DOC21/563579-13

SSD-8304 – Liquid Waste Treatment Facility
DGL Group Limited (formerly Hydromet Corporation Pty Ltd) – Unanderra Plant

ATTACHMENT A

AIR QUALITY

Figure 3: Predicted annual average Pb concentrations ($\mu\text{g}/\text{m}^3$)

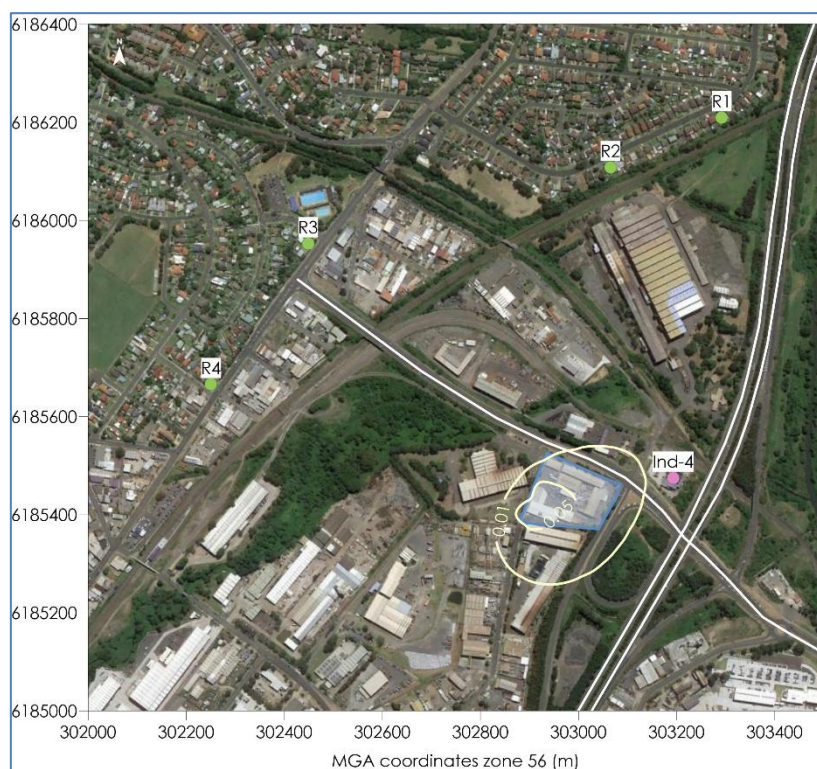
Furthermore, it is noted that Table 7-3 and associated Figure 7-9, lists the impact assessment criterion for lead as $0.5 \mu\text{g}/\text{m}^3$ at 1-hour average, rather than annual. Whilst it is likely a typographical error, and it is recognised that a 1-hour criterion presents a more conservative approach, for complete transparency it should be corrected in the revised assessment.

- 1) Consider potential for ground level impacts at the swim-school (McKeon's Swim Centre) located on the corner of Marley Place and Five Island Rd, Unanderra.**
- 2) Address identified inconsistencies between the AQIA and Approved Methods for the Modelling and Assessment of Air Pollutants in NSW in regards to correct averaging periods for assessing impacts of lead emissions.**
